Our Ref: B:\00-3655_Lot 490 Casuarina Way, Kingscliff\
Enquiries to: Brad Comley, Steven Chamberlain, and Kristina Entwistle

Re: Proposed Development – Lot 490 Casuarina Way

Please find below responses to comments issued by the New South Wales Department of Planning (DOP) and other relevant agencies in correspondence dated 4 June 2010.

FIGURE 4.4 -
OPERATIONAL CONTROL
PLAN

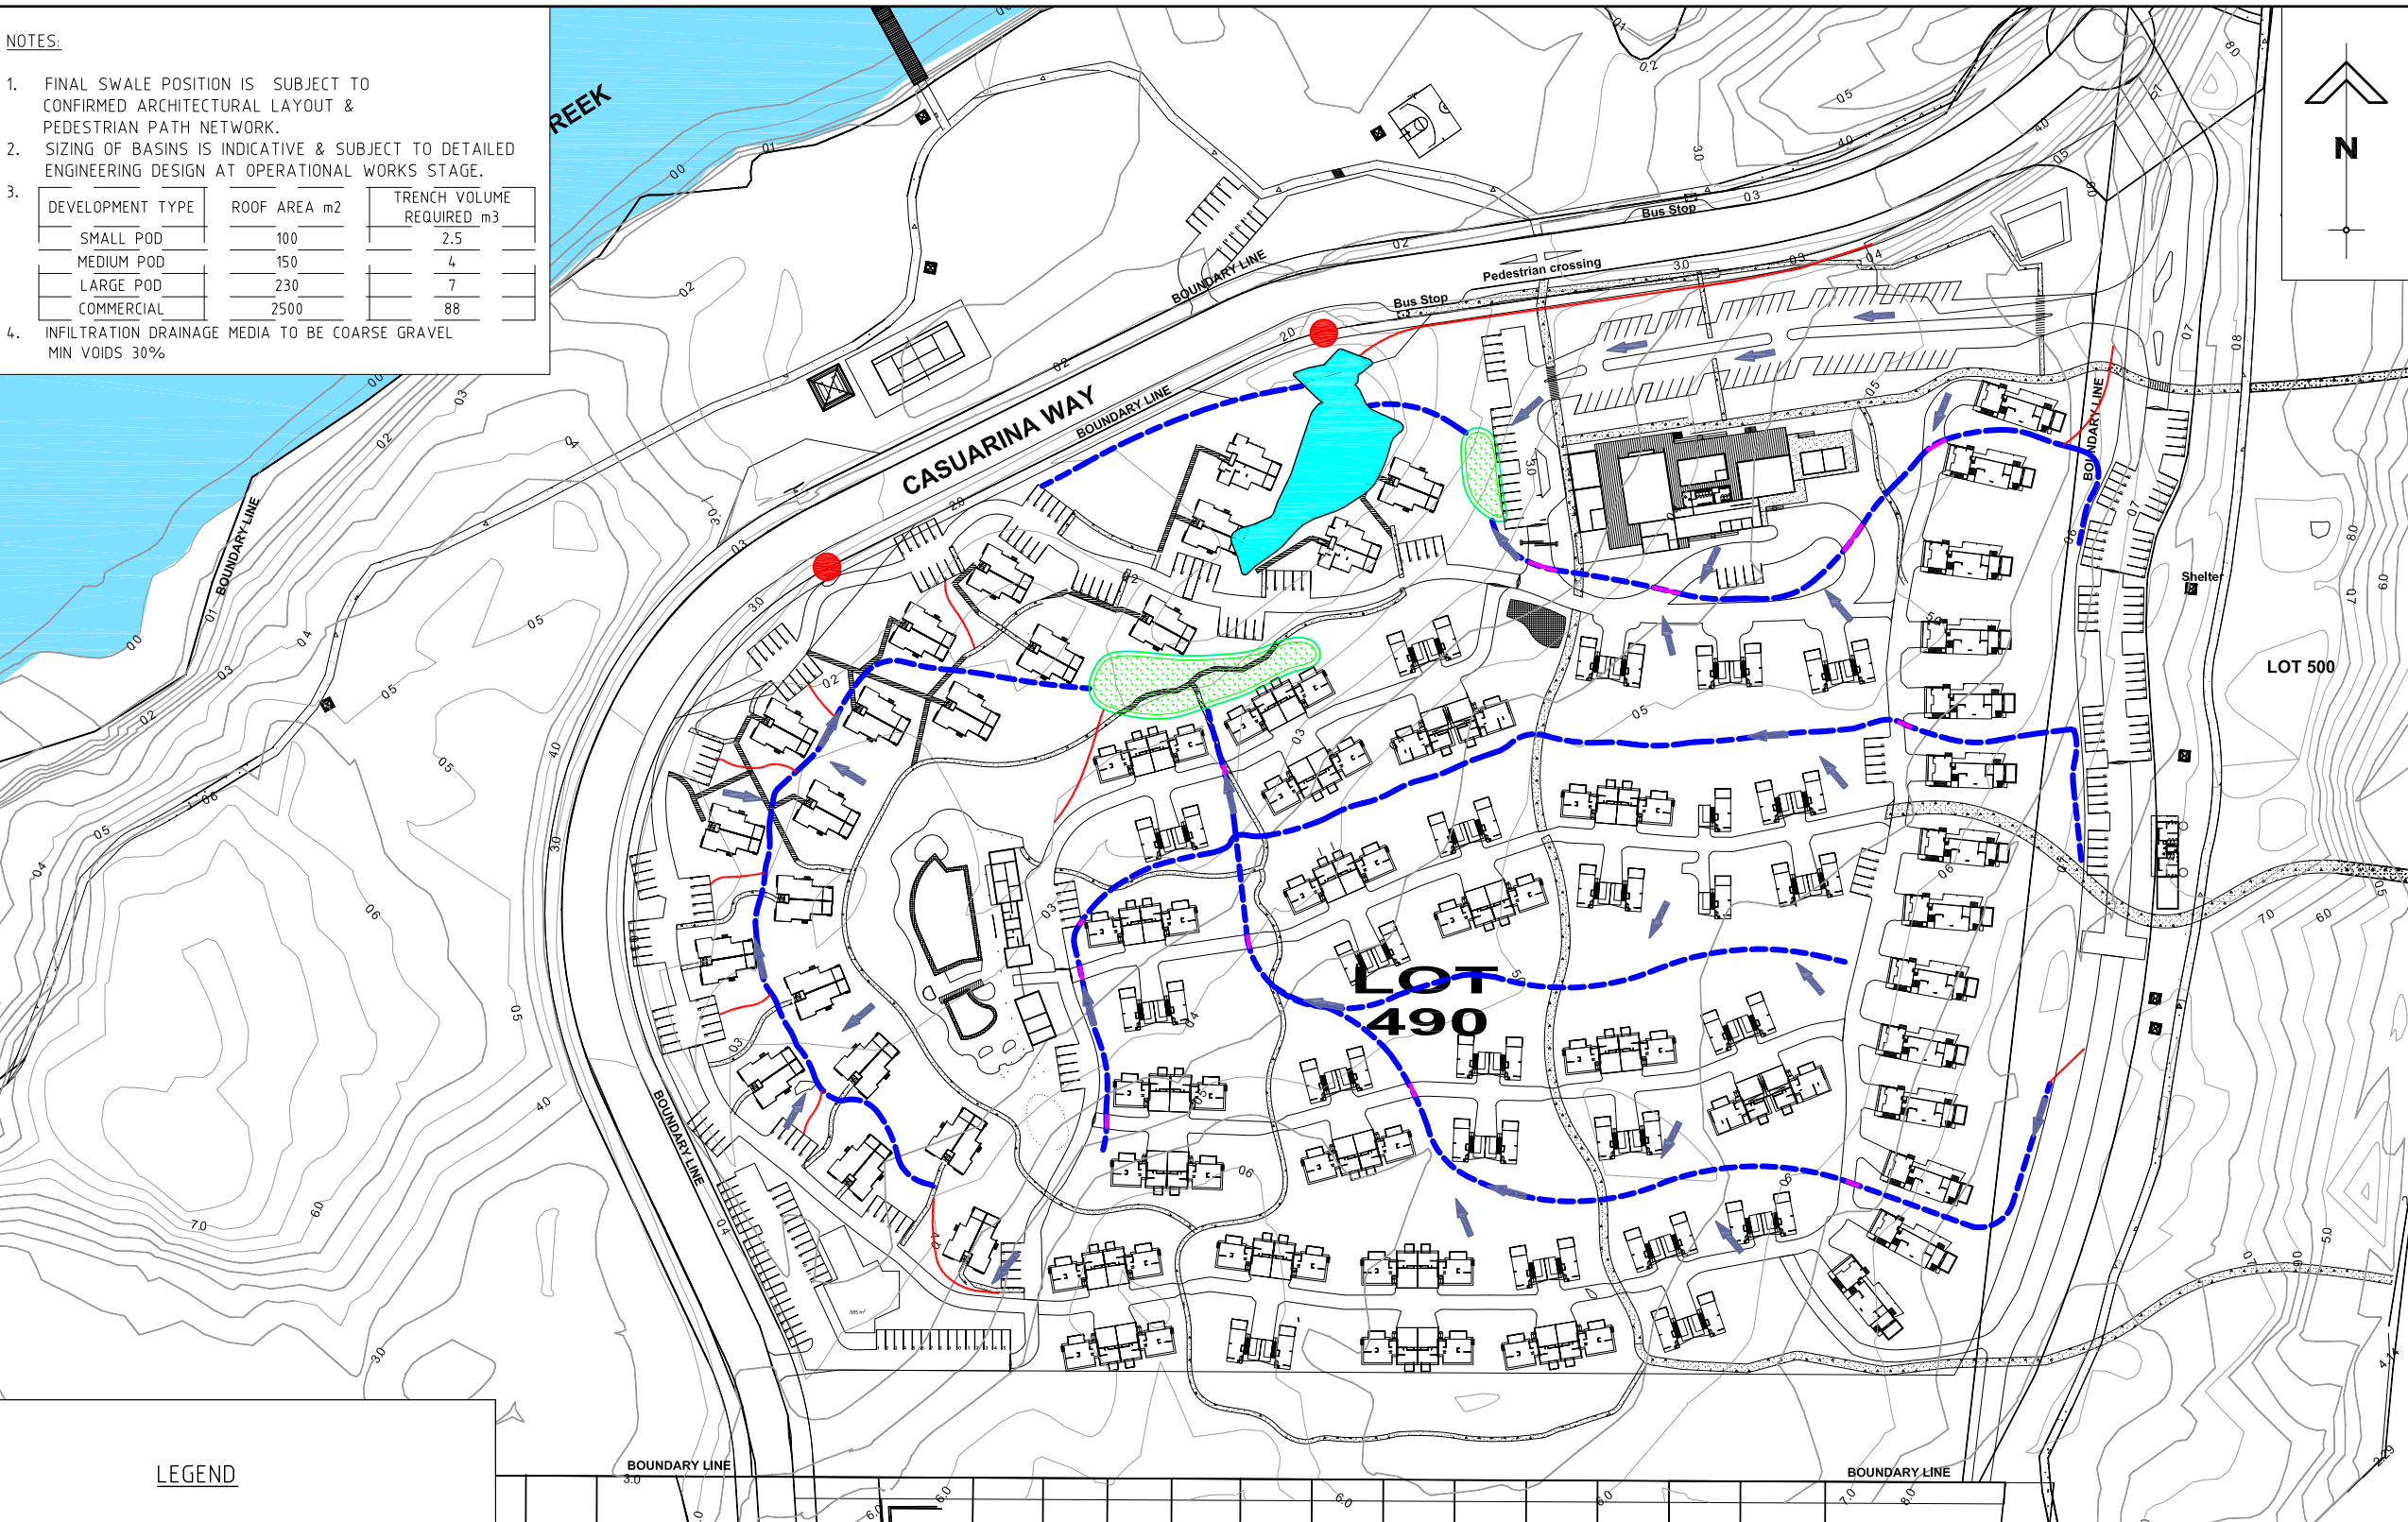
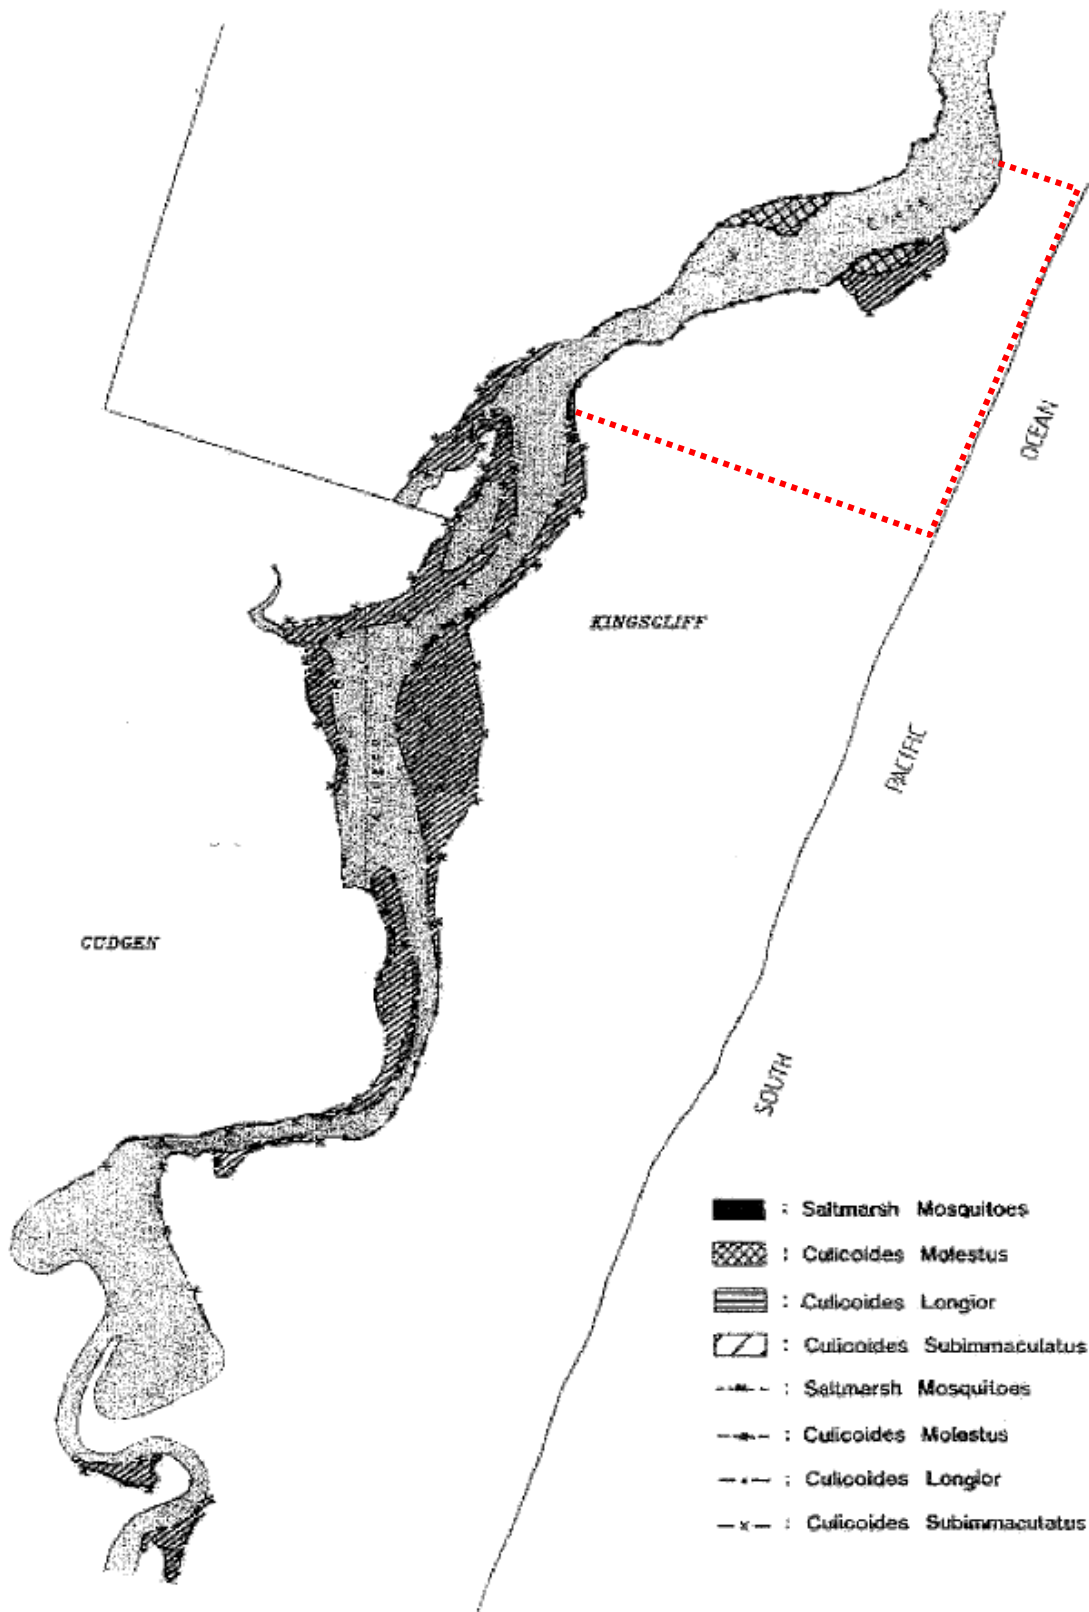
Appendix G 'Stormwater Drainage System Plan' (under 'Infrastructure/Stormwater Management') is inconsistent with Figure 3.3 'Operational Control Concept Plan' (under 'Infrastructure/Stormwater Management'), in relation to the number and configuration of stormwater swales.

Figure 15 'Existing Site Vegetation' in the EA shows an area of Vegetation Community 3, which is representative of the EEC 'Swamp Oak Floodplain Forest of the NSW North Coast, Sydney Basin and South East Corner bioregions' occurring within the Resort Premises (that is, on the eastern side of Casuarina Way). It is not entirely clear how this area will be managed, given its small size and relative isolation. It is noted the 'Stormwater Drainage System Plan' in Appendix G of the 'Infrastructure Provision Report' (Volume 3) shows two stormwater swales draining into this Community. LPMA does not support any proposals that would see concentrated stormwater flows directed towards this or any other EEC.

It is unclear how many legal points of discharge exist for the Resort Premises. The ‘Stormwater Drainage System Plan’ (Appendix G, ‘Infrastructure Provision Report’) shows two, but a number of other plans only show one.

LPMA considers all stormwater infrastructure must be located on Lot 490. Figure 13 ‘Stormwater Control Plan’ of the EA shows a swale on Lot 500. No stormwater infrastructure is to be placed on Lot 500, in order for revegetation opportunities`

The Operational Control Plan and Appendix G 'Stormwater Drainage System Plan' have been revised to remove any inconsistencies between the two plans. Please find a copy of both of these plans as an attachment to this letter.

The proposed stormwater system has been revised to ensure the swales do not enter the EEC area. Please refer to the revised Operational Control Plan and Appendix G 'Stormwater Drainage System Plan' included as an attachment to this letter.

The “primary” Legal Point of Discharge (LPD) is located at the existing culvert under Casuarina Way at the outlet of the proposed treatment wetland. A “secondary” LPD is provided by another existing culvert under Casuarina Way. However, due to the work to be undertaken on the site and the redirection of flows towards the treatment devices, only a very small portion of the site that remains undeveloped will continue to flow to the “secondary” LPD. The revised Operational Control Plan and Appendix G ‘Stormwater Drainage System Plan’ both indicate the two LPDs.
